13 August 2019

Director - Social & Other Infrastructure Assessments  
Department of Planning, Industry & Environment  
GPO Box 39  
SYDNEY NSW 2001

**RE: SSI 9775 - NEW MAITLAND HOSPITAL (STAGE 2)  
METFORD ROAD, METFORD (LOT 7314 DP 1162607 AND PART LOT 401  
DP 755237)**

Figure 12 | Indicative proposed layout of the Chelmsford Drive/Metford Road roundabout (Source: PIR)

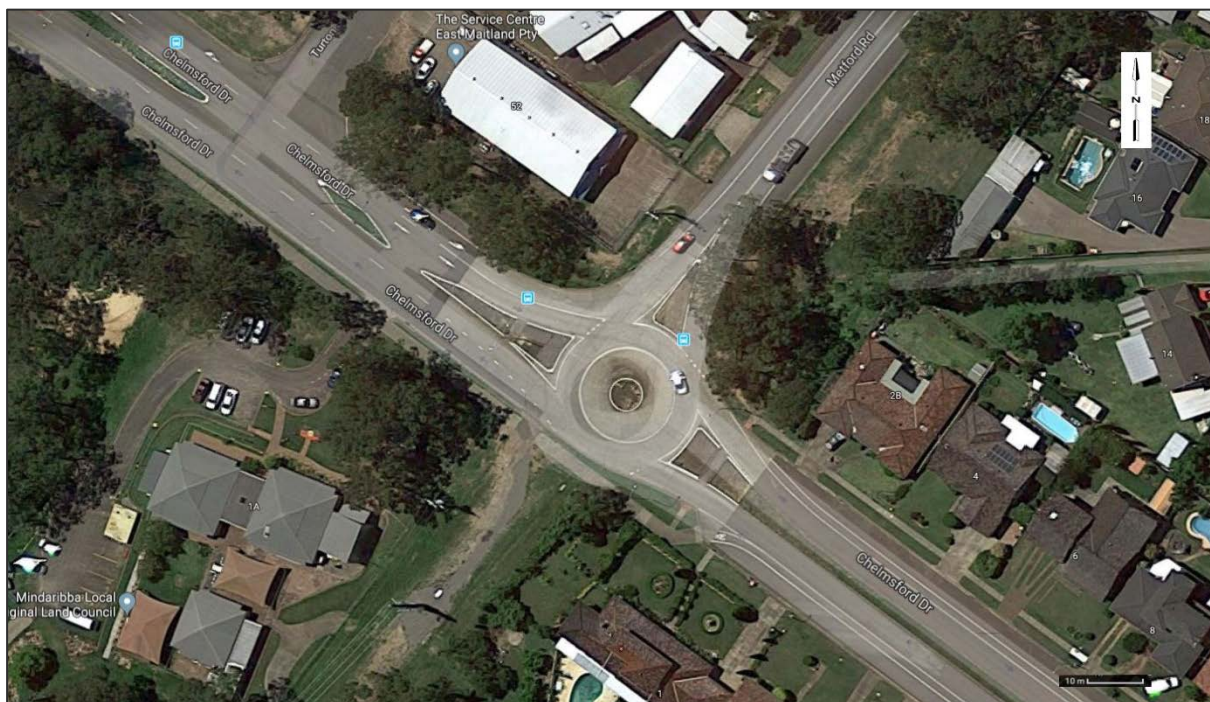
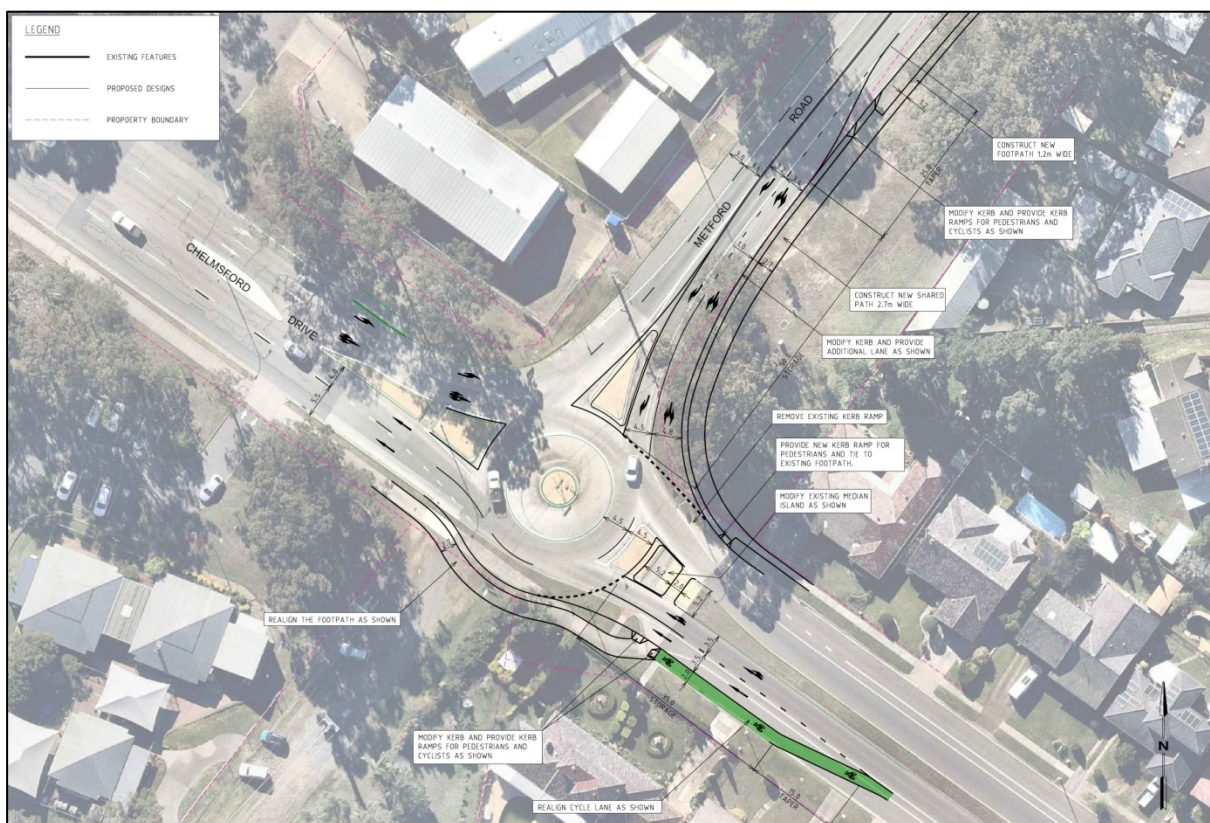
- the scope and timing of Chelmsford Drive/ Metford Road roundabout upgrade (NB: it is acknowledged that HI have committed to completing the upgrade of the Metford Road/Chelmsford Drive roundabout prior to the hospital becoming operational);
- the scope and timing of Metford Road corridor planning and Metford Road widening to four (4) lanes;
- the performance of Fieldsend Street/ Metford Road roundabout for 454 vehicles/peak hour trips including U-turns from the secondary access;
- the scope and timing of a shared path on the east side of Metford Road (with lighting) to provide connectivity with other paths to Green Hills precinct and to existing shared path on Fieldsend Street.

- Chelmsford Drive/ Metford Road roundabout upgrade;
- Any identified upgrades to Fieldsend Street/Metford Road roundabout to cater for 454 vehicle/peak hour trips, including U-turns from the secondary access;
- Provision of a shared path on the eastern side of Metford Road (with appropriate lighting) linking up with other existing paths, including the existing shared path on Fieldsend Street, to provide pedestrian/cyclist connectivity between the NMH site and the Green Hills precinct; and
- Traffic management conditions around the helipad (Source: s7.5 GTA report).
